Your Ref: OWPC24452
Our Ref: LU/282/19/PL 11-09-2019
Please ask for:
Zac Denton

Replacement of 6 No. windows in communal hallway from single glazed in wood frames to double glazed PVCu.

The Swallows St Catherines Road Littlehampton

FLATS 1 - 6 EXISTING WINDOWS

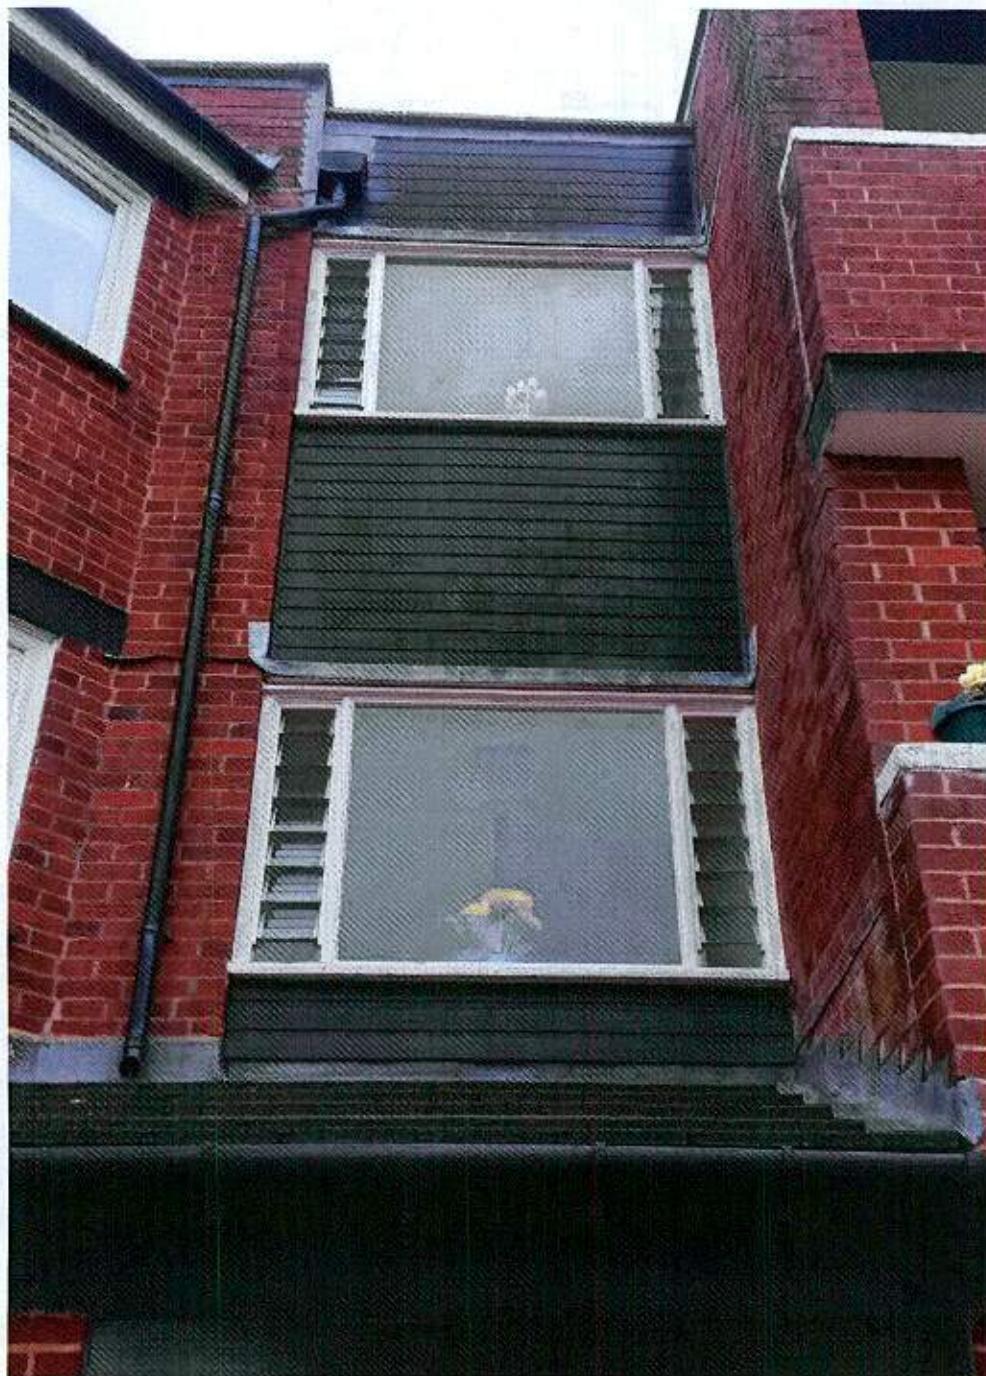
*I have always admired the design of this building because, although dating to the early 1970's, it is extremely well proportioned and finely detailed.
It makes a positive contribution to the Area of Character and occupies a very prominent location opposite Caffyn's Field.
The existing windows, through their frame patterns and proportions, are sympathetic with, and add quality, to the appearance of the building.*
